MEMORANDUM:

To: Greg Gilbert – CEO / Plan Reviewer, City of Portland, Maine

Subject: BP# 2017-010136_7 Diamond Pass

Hello Greg – Thank you for your recent feedback and questions. In response to your request for corrections and/or additional information on our drawings and specifications please see the following notes.

A-101B

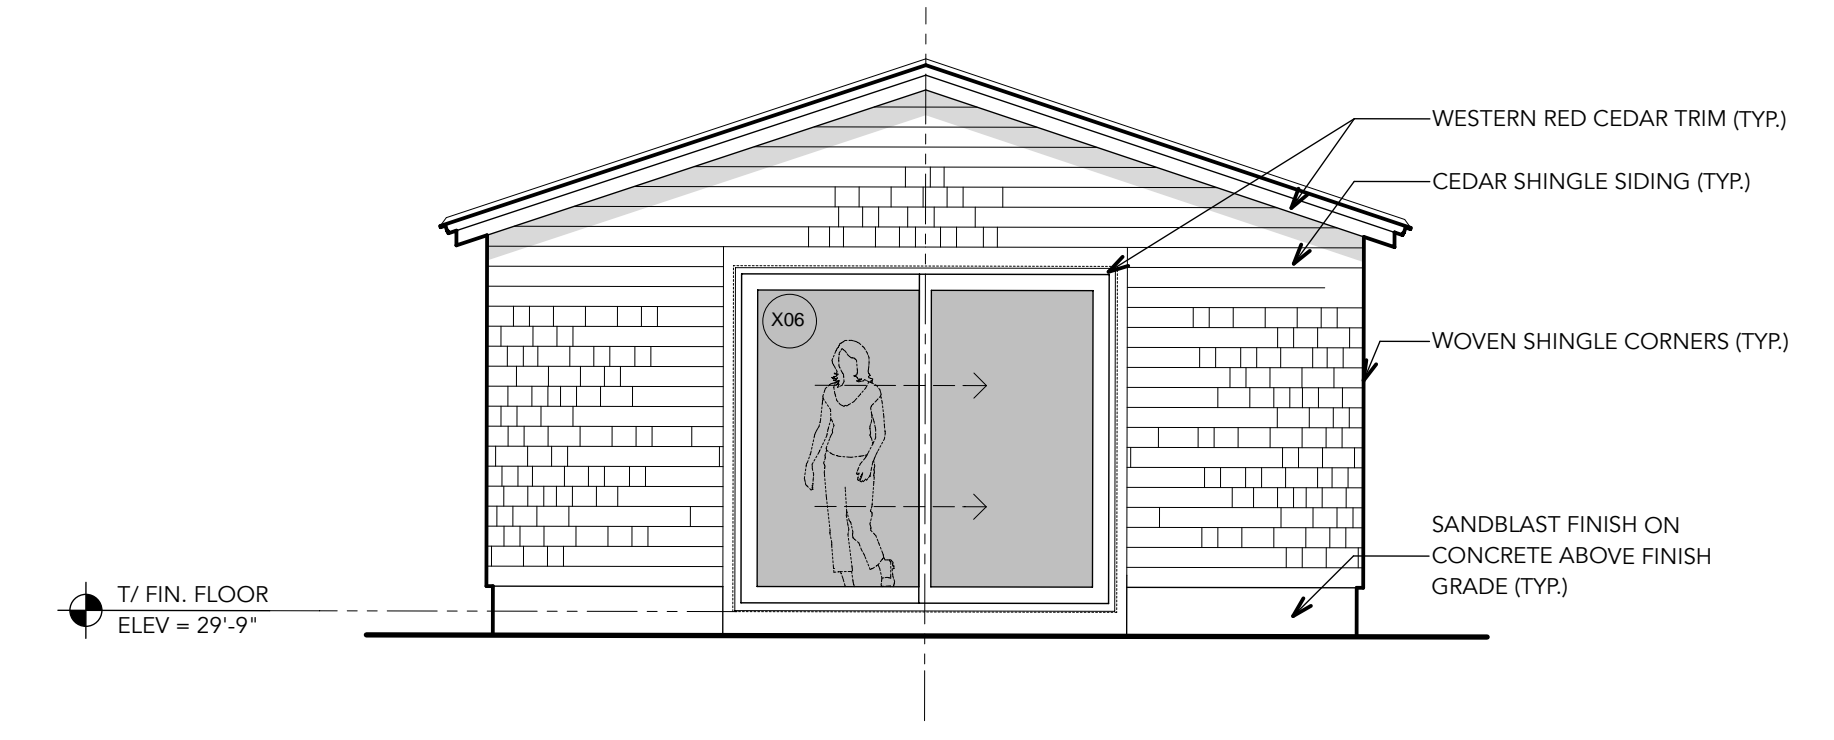
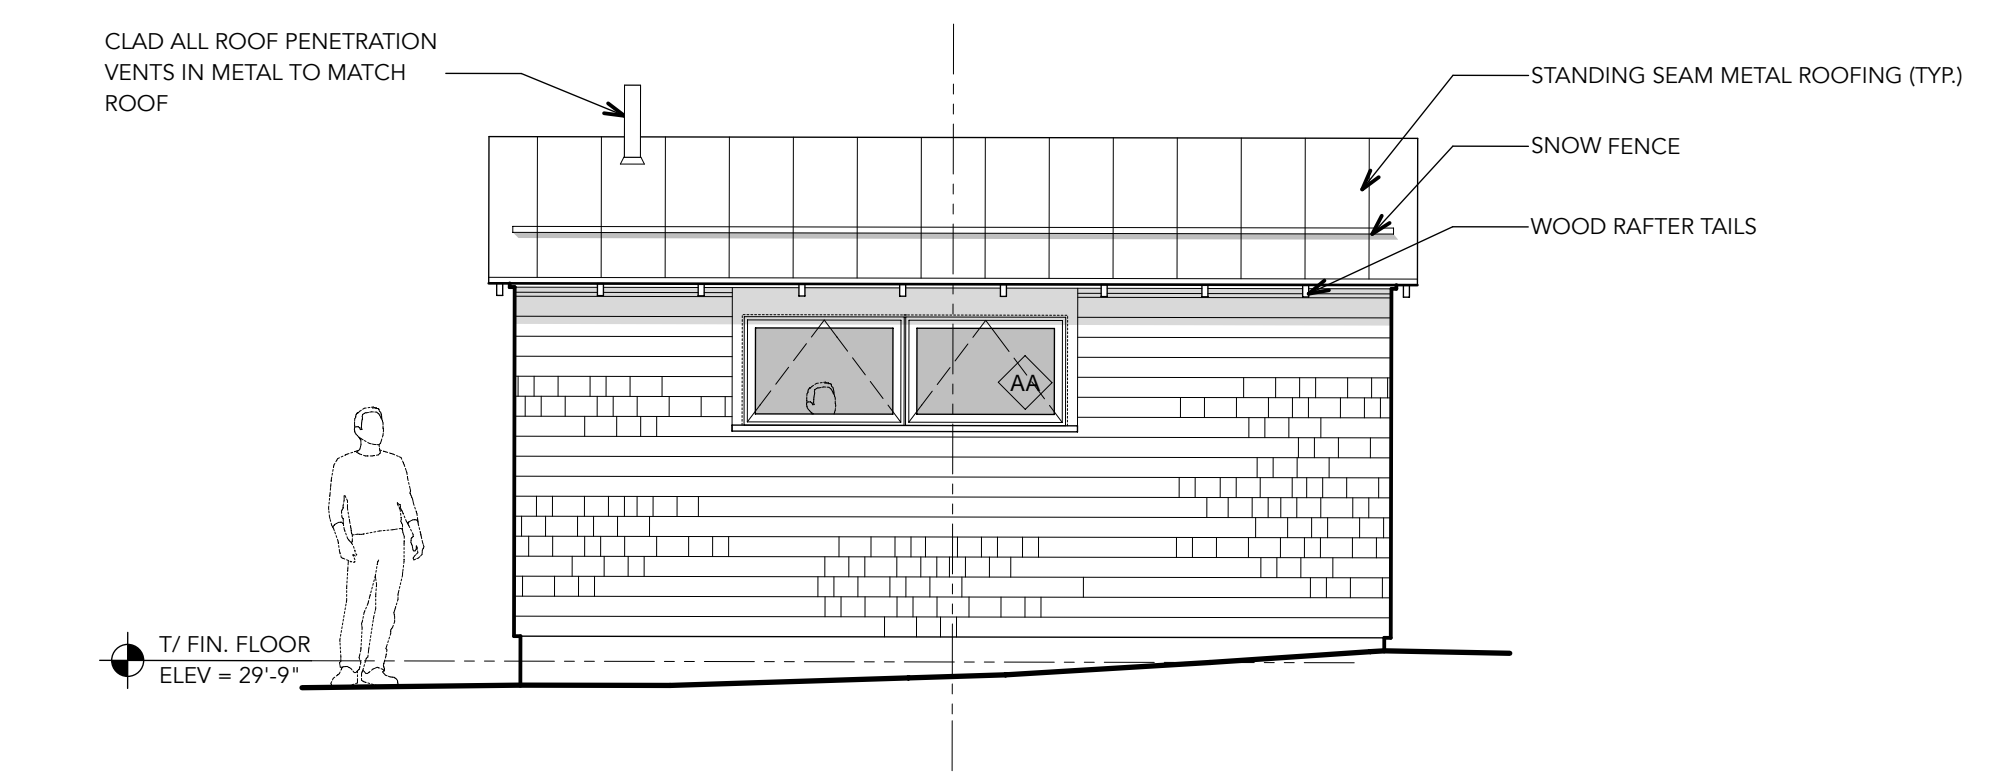
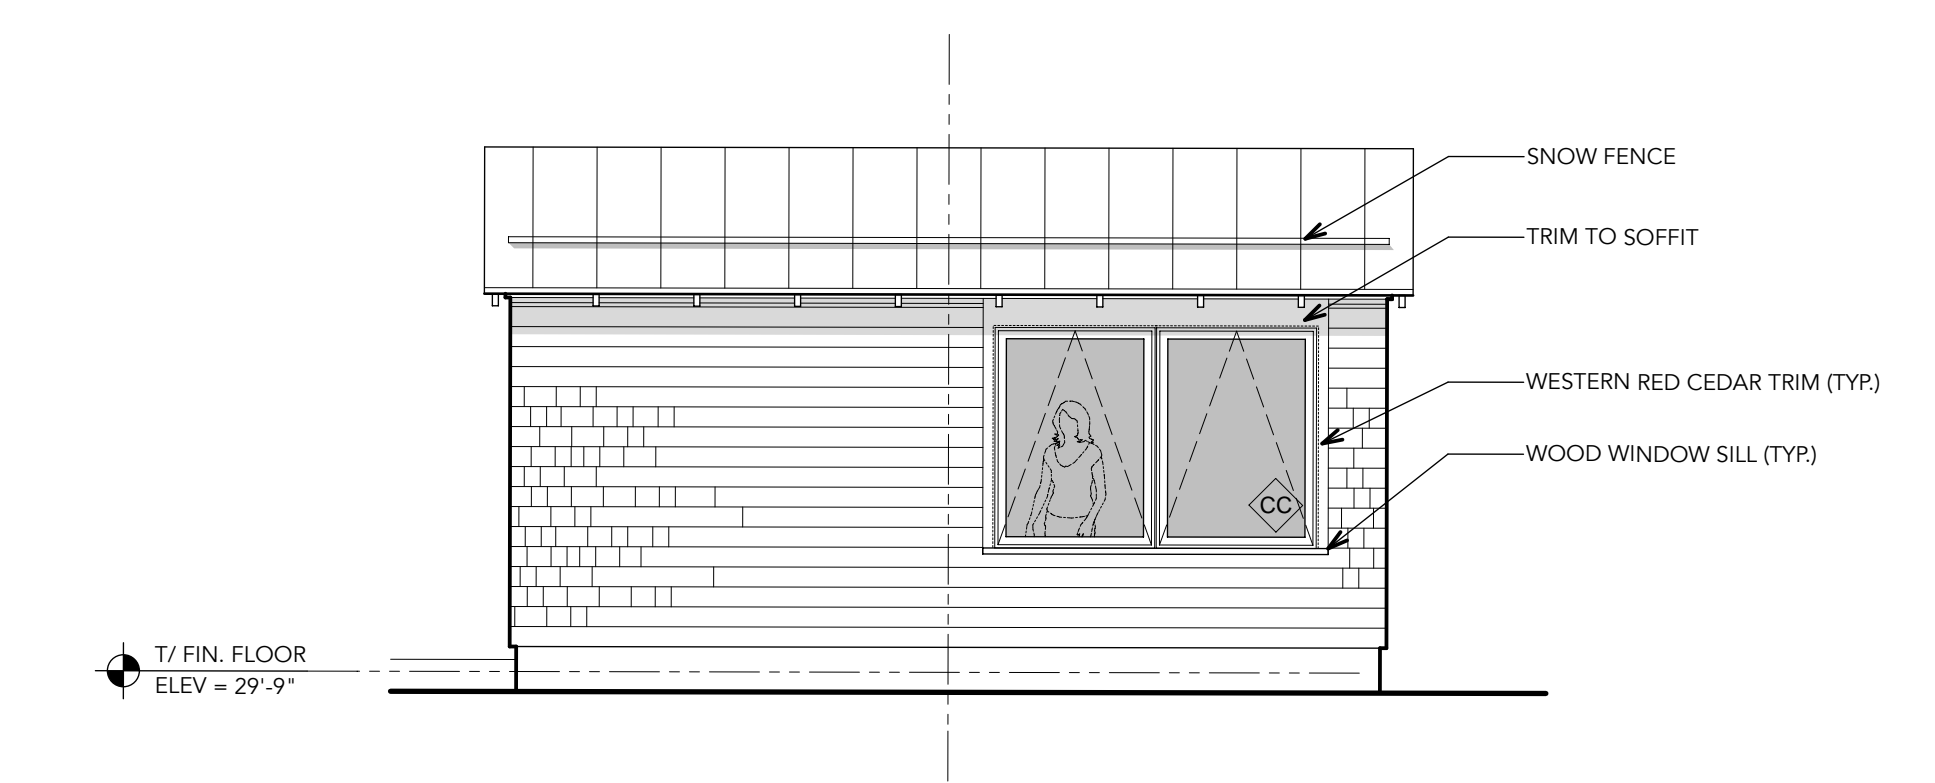
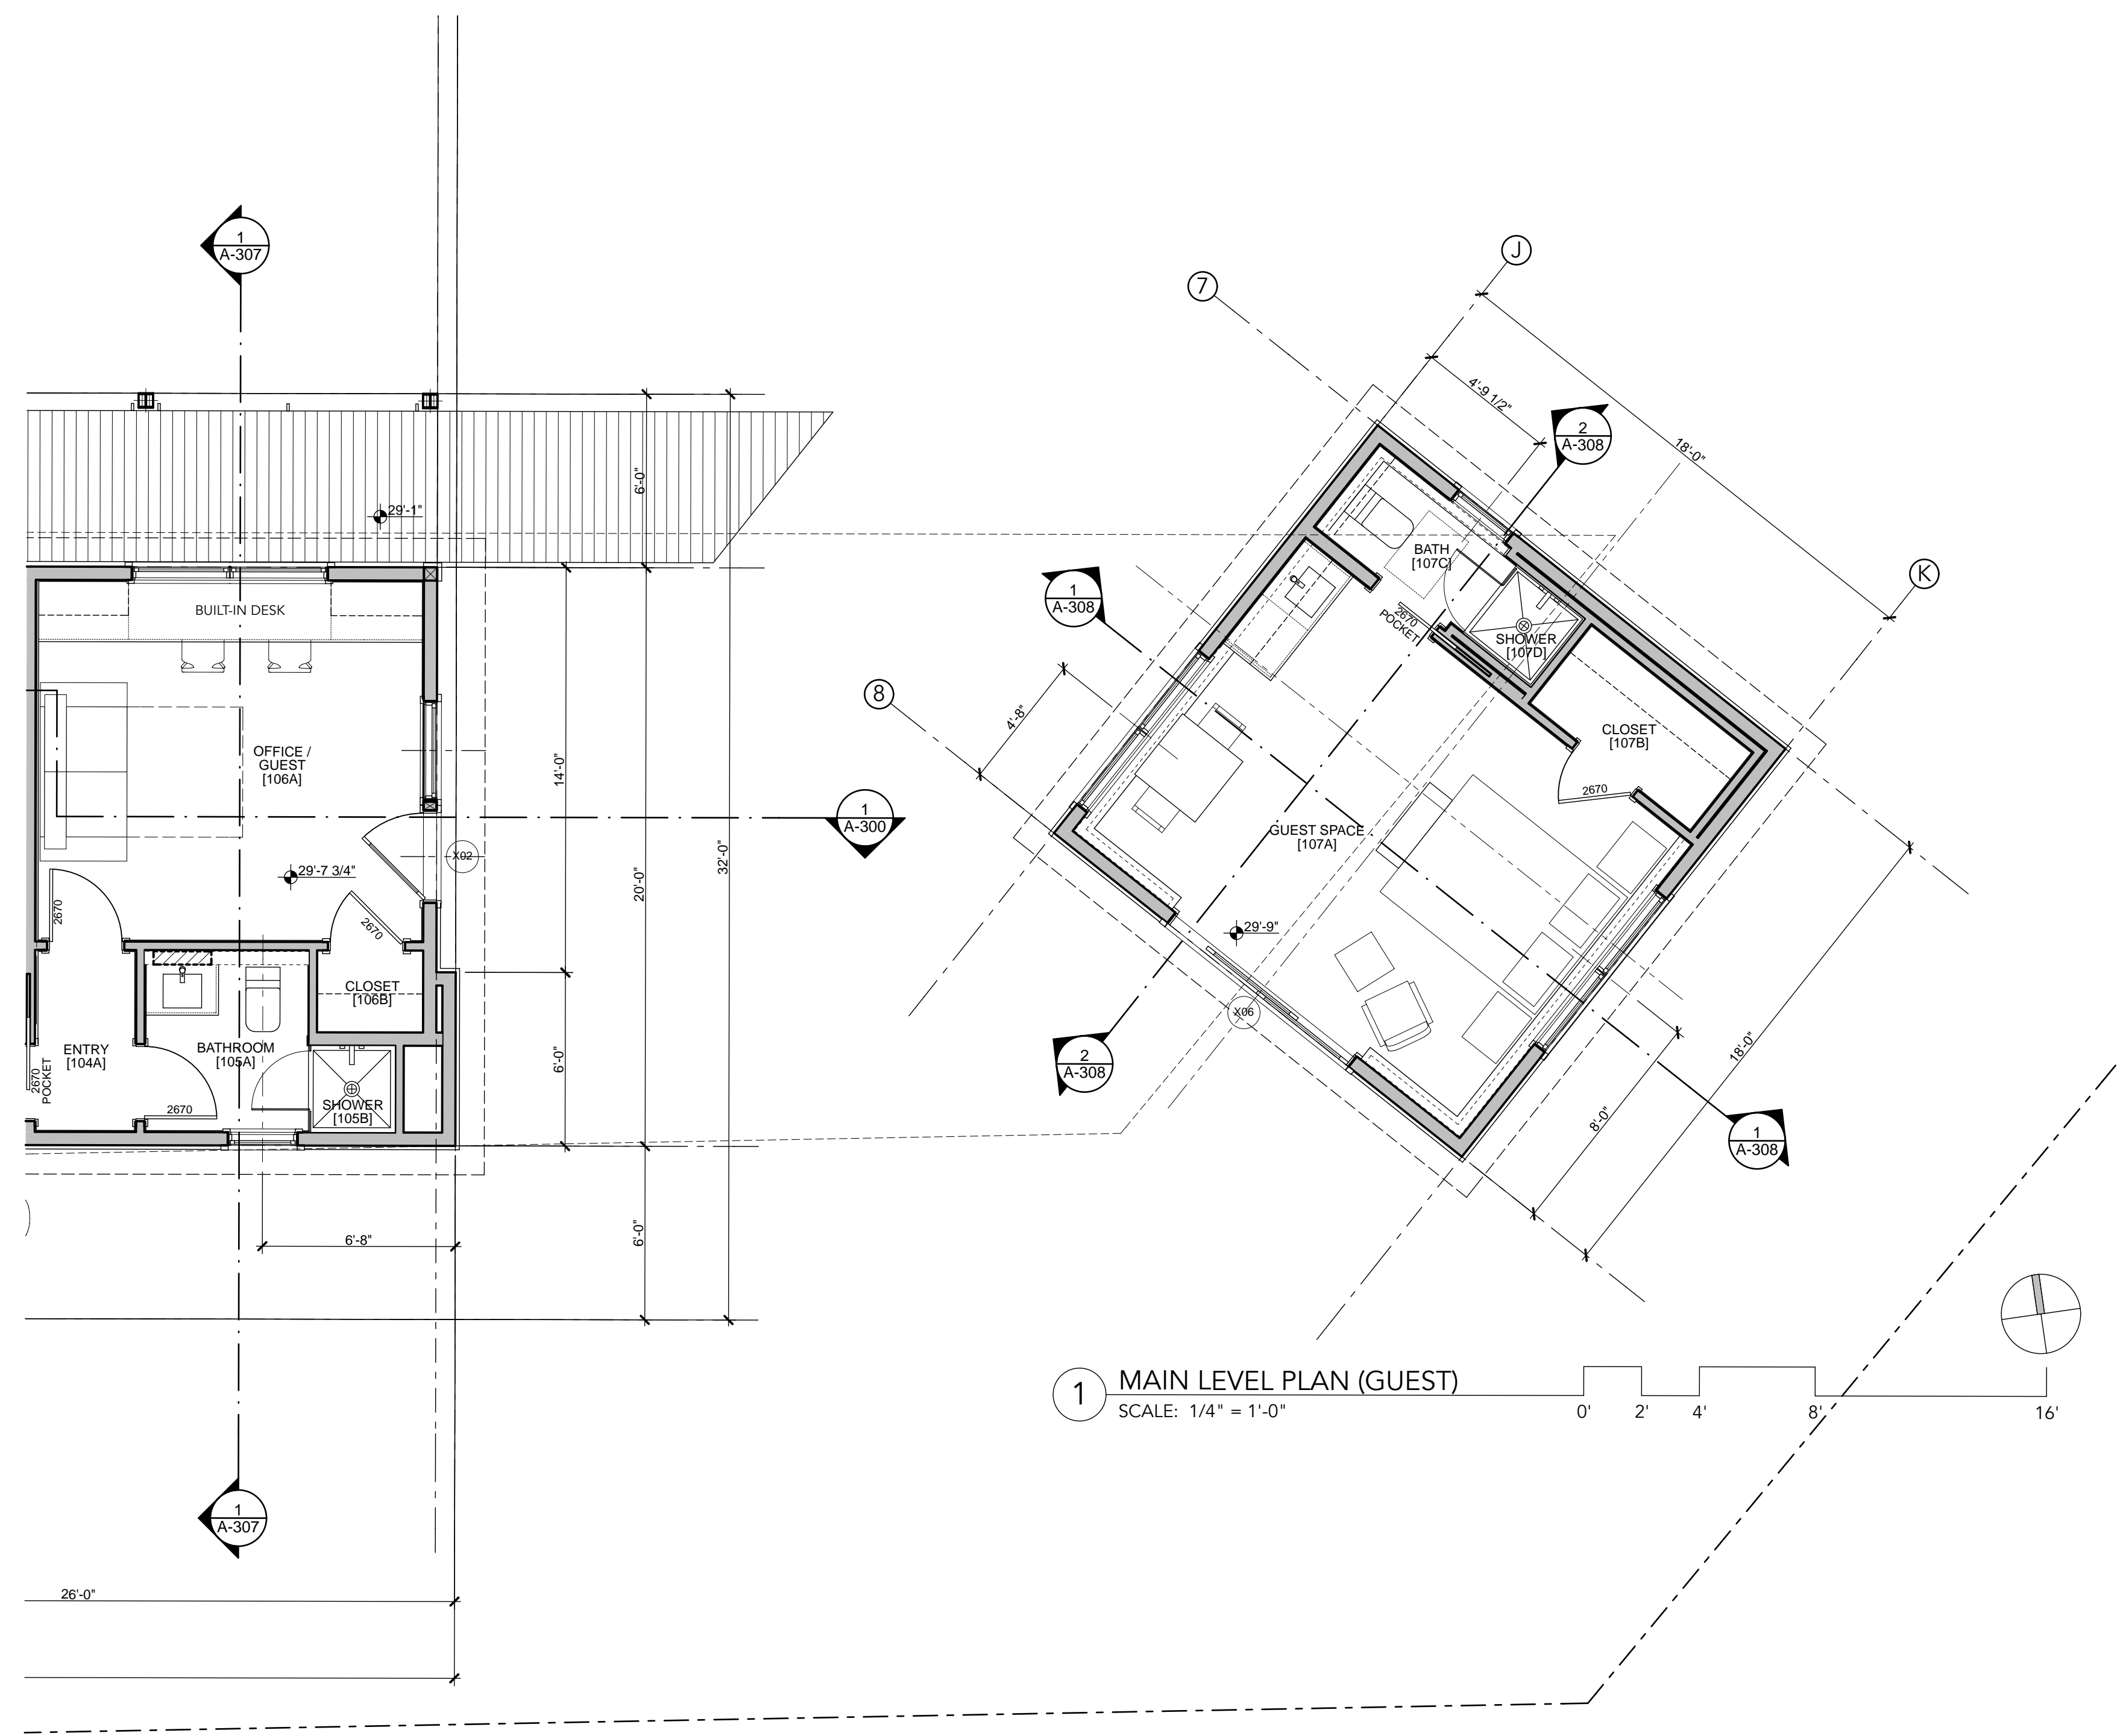
- “Distinguish what windows meet emergency egress requirements based on clear opening (not rough opening)”:
 - We’ve added notes to our exterior elevations showing clear opening dimensions, provided by the manufacturer, for each window or door that we are designating as emergency egress. Please see revised sheets A-101B, A-200, & A-201.
